Town & Country Planning Act 1990 (as amended)

Approval of details reserved by condition imposed under ref EP/179/18/PL relating to Condition Nos 3 - surface water drainage, 4 - visibility splays, 5 - car parking & turning arrangements, 6 - covered & secure cycle parking, 7 - materials & finishes, 8 - hard & soft landscaping and 10 - existing wall to south

Gladwyn The Street East Preston BN16 1HT

Scales: 1:50 1:200
No: 2386/01/12

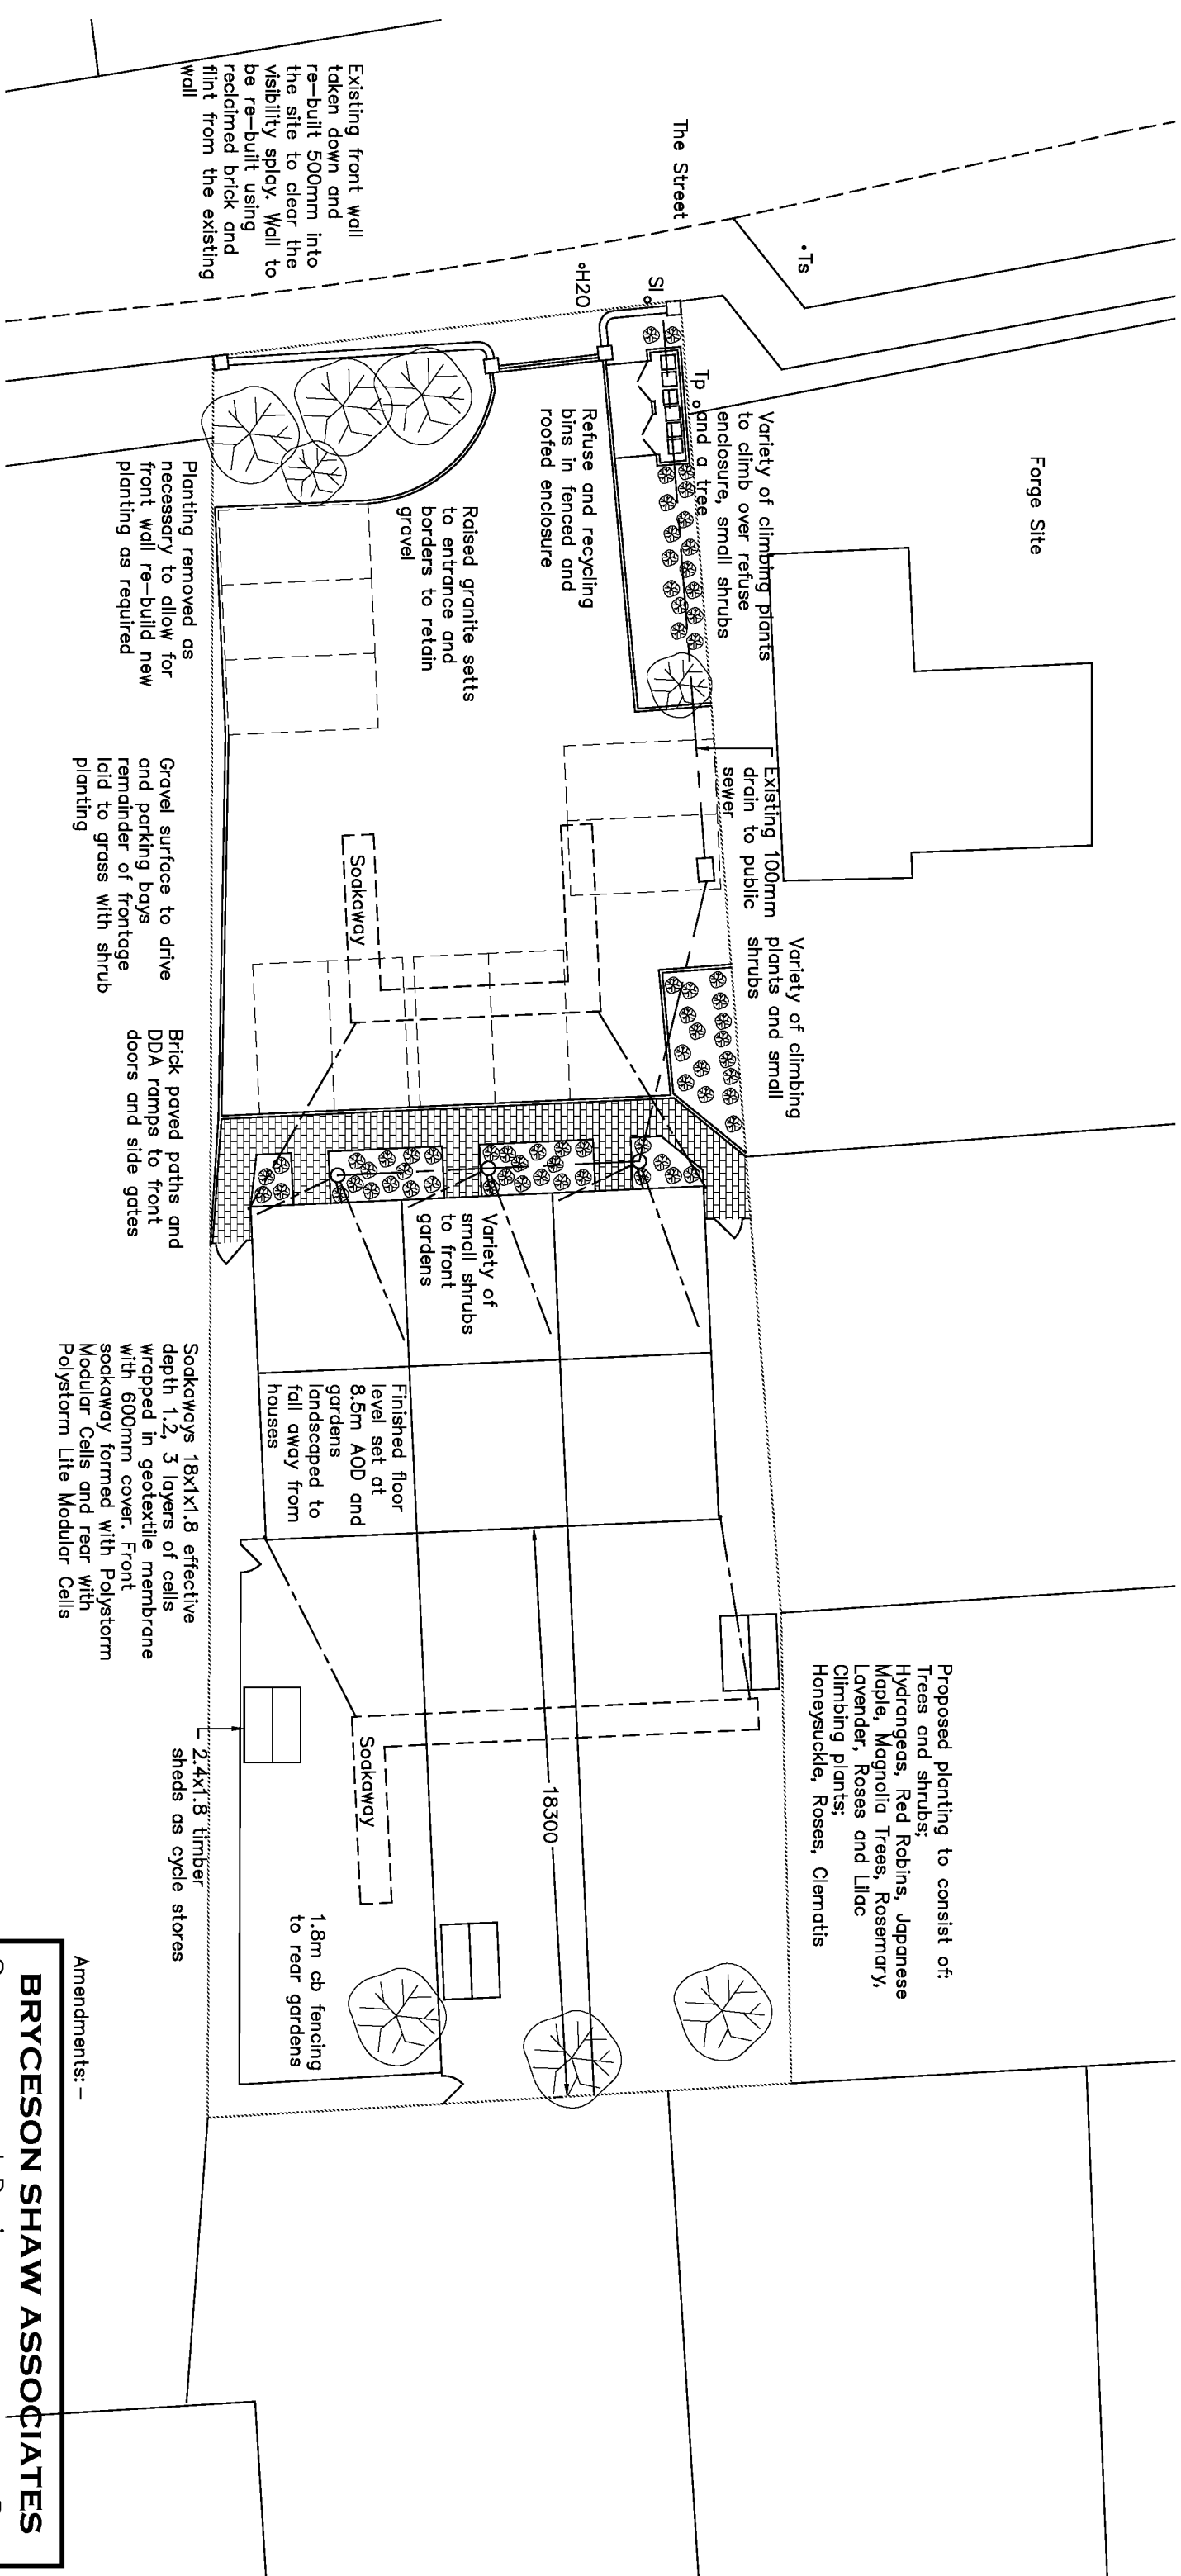
This condition is approved in so far as submission of details relates and refers to the submitted photographs and the wall elevation details on drawing Landscaping and External Works 2386/01/12 dated May 2020 which indicate a coursed flint wall with closely spaced flints and little visible mortar.
